## Appeal Decision

**Appeal Ref: APP/R5510/D/24/3355934**

**2 Middleton Drive, Hillingdon, Eastcote HA5 2PG**

- The appeal is made under section 78 of the Town and Country Planning Act 1990 (as amended) against a refusal to grant planning permission.
- The appeal is made by Mr Muhammad Masood Elahi against the decision of the Council of the London Borough of Hillingdon.
- The application Ref is 50922/APP/2024/1732.
- The development proposed is a single storey rear extension.

client	MR MASOOD ELAHI		site	2 MIDDLETON DRIVE, PINNER, HA5 2PG.	
project	SINGLE STOREY REAR EXTENSION			title	FLOOR, SITE & BLOCK PLANS
scale	1:100 @ A3	date	18/06/2024	drawn by;	SAK
number	2MD/PN01		revision	C

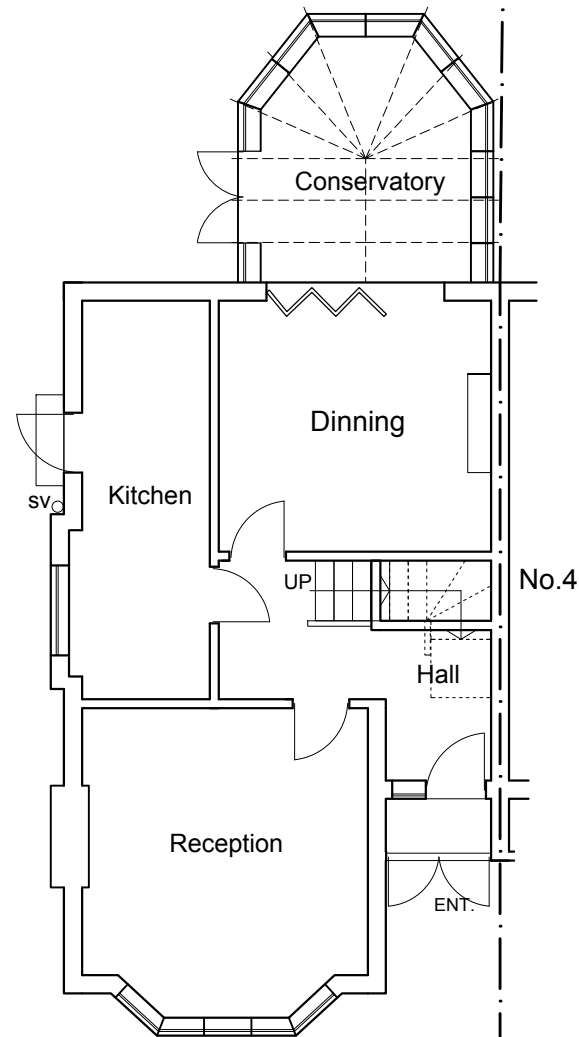
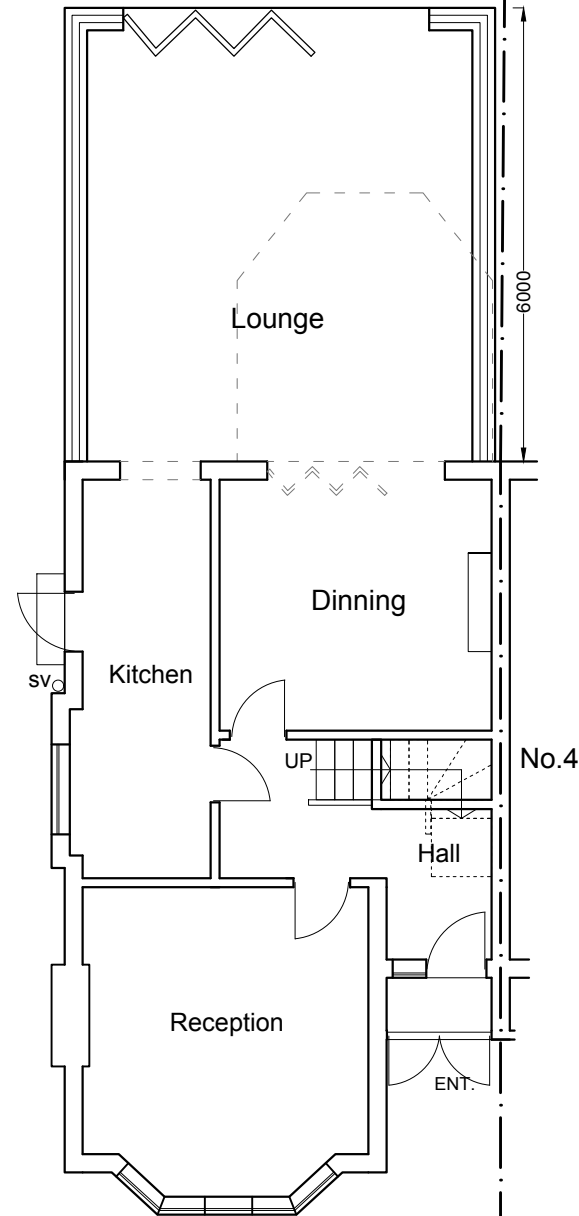
6. The appeal property currently has a single storey conservatory, although built close to the boundary with No. 4, it is of a fairly modest design that insets away from the boundary at the rear and does not appear to unduly impact the living conditions of the occupiers of No.4.

7. The appeal property and No. 4 are separated by a fence and sparse hedge. The proposed extension would be a significantly larger addition than the existing conservatory with no gap from the common boundary with No.4 and would project above the existing fence and hedge. Having regard to the height and depth of the proposed extension and the position of the rear doors and windows at No. 4, the proposed extension would appear as an unduly overbearing and oppressive addition from No 4's rear habitable room windows and adjacent garden, and an unacceptable level of harm to outlook would therefore arise.

8. I accept that the orientation of the rear of the properties means that the proposed extension would not block direct sunlight reaching No. 4s rear ground floor window and door. However, the proximity and scale of the extension would reduce the levels of natural light currently experienced and overall would have an adverse effect on the available light levels in the neighbouring property.

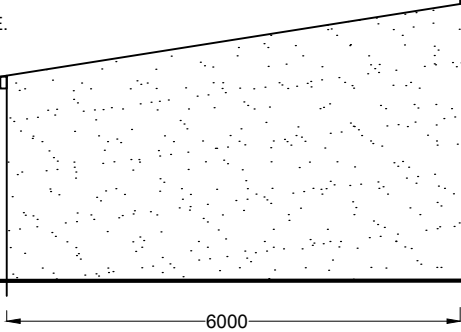
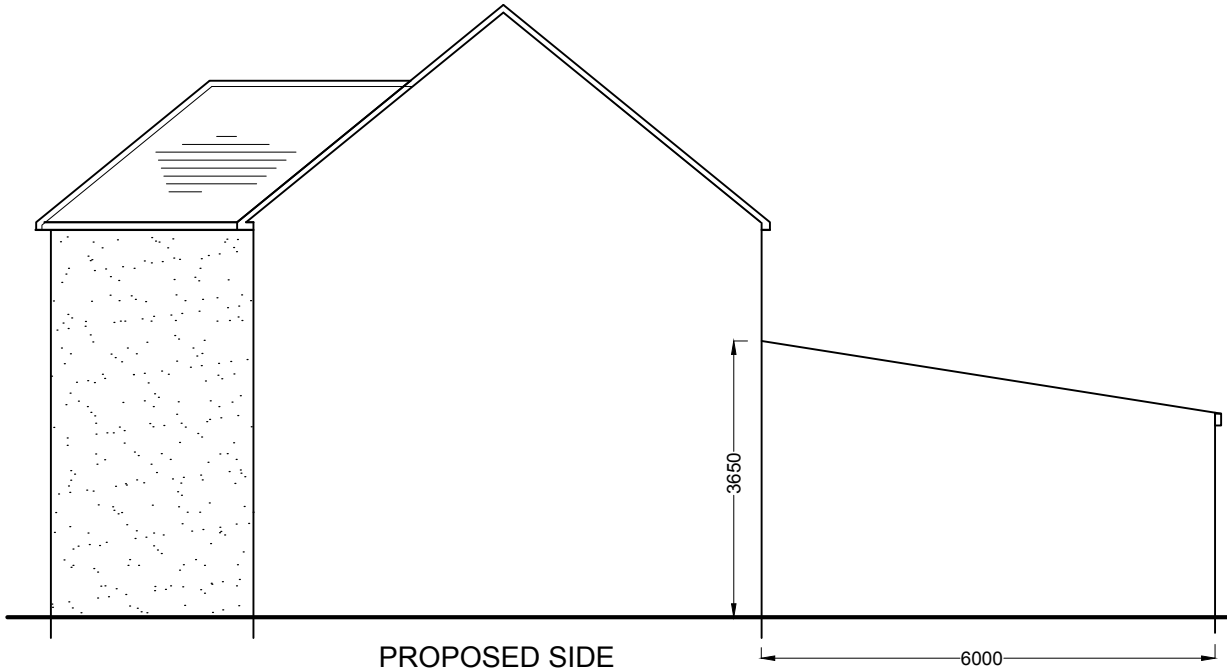
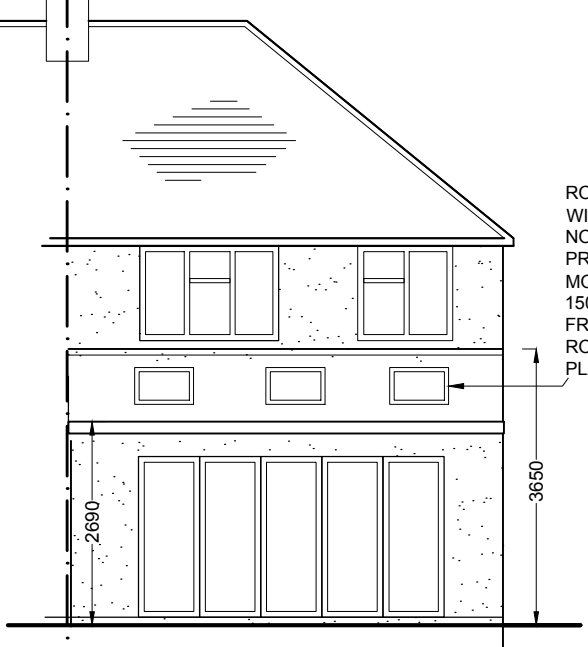
10. The appeal property is currently a well-proportioned semi-detached dwelling, which possesses a comparatively modestly sized rear garden. The scale and design of the proposal is such that it would compete with and overwhelm the scale and character of the appeal dwelling with the resultant development amounting to a dominant addition which would have an adverse impact on the character and appearance of the appeal property, No.4, and to a more limited extent, the surrounding area. Although I accept that there would also be a consequent loss of garden space, I am satisfied that a reasonable usable area of garden would be retained for use by occupiers.
